PR-2023-008549

SD-2023-00228 – PRELIMINARY/FINAL PLAT

REQUEST: LOT CONSOLIDATION FOR 3 LOTS INTO ONE LOT

Planning Comments

SITE PLAN
(existing conditions)

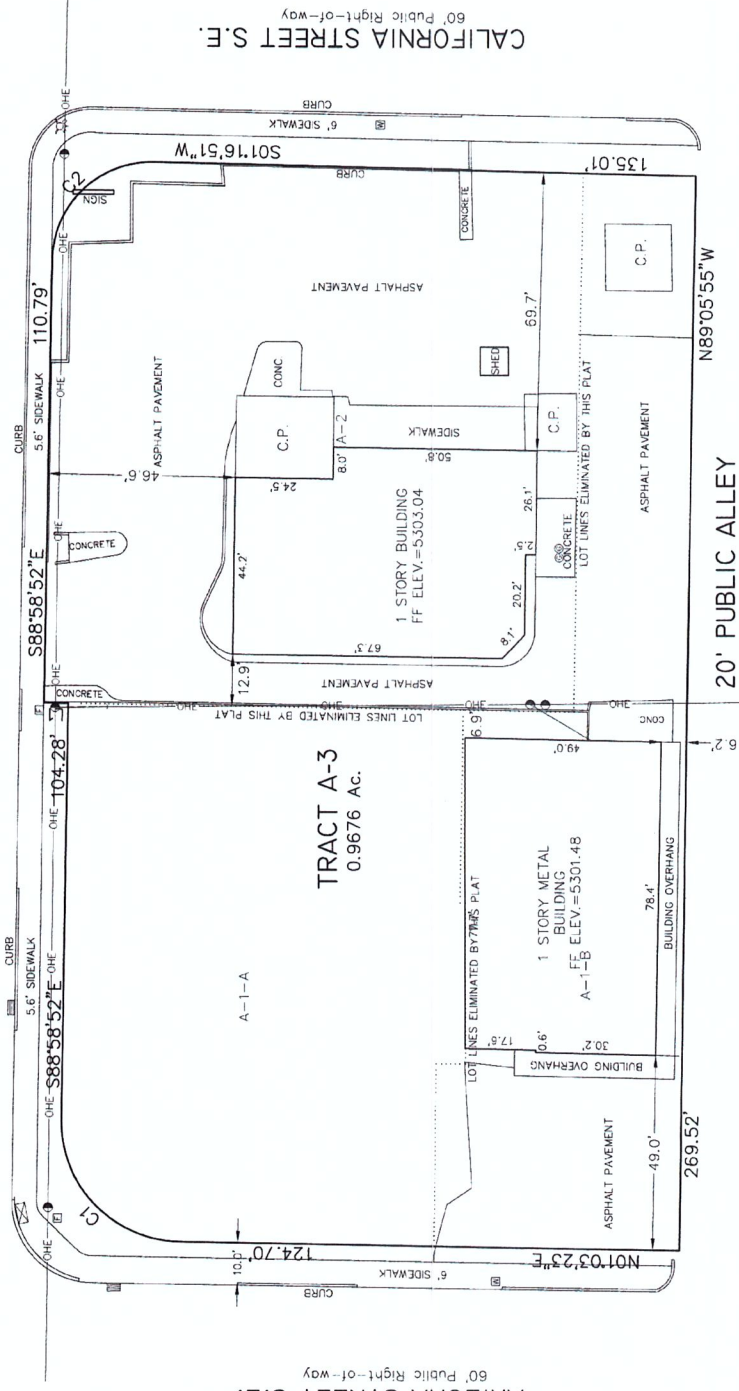
- Please confirm the proposed request is only for the lot consolidation replat. New development proposed for the site will trigger bringing site up to current IDO standards.
- Please clarify if all three lots and buildings are a part of the same development and existing uses? There are currently separate lots, buildings, and entrances. They are all separately fenced.
- Please clarify if the proposed replat will be affecting the existing alley or any previous vacation?

- Please clarify and demonstrate that the existing development will be meeting the required dimensional standards and not creating a nonconformity.
 - Please clarify and demonstrate that parking calculations are being met. Clarify if a shared parking agreement will be needed.

- Demonstrate compliance with **section 7 of the DPM Table 7.2.29** and Required Improvements section from 5-4(N) of the IDO. *In regards to the Sidewalk width requirements and the accompanying landscape buffer.
Provide measurement for the existing ROW and distance from curb to property line along street frontages.

****Verification of standards per Transportation****
Zuni Rd. is a Principal Arterial. Requires 6ft Sidewalk and 5-6 ft Landscape/Buffer Zone. Zuni also has a Bike Lane.
Arizona St. is a Local Street that requires a 5ft Sidewalk & a 4-6 Landscape/Buffer Zone.
California St. is a Local Street. Requires a 5ft Sidewalk & 4-6 Landscape/Buffer Zone.
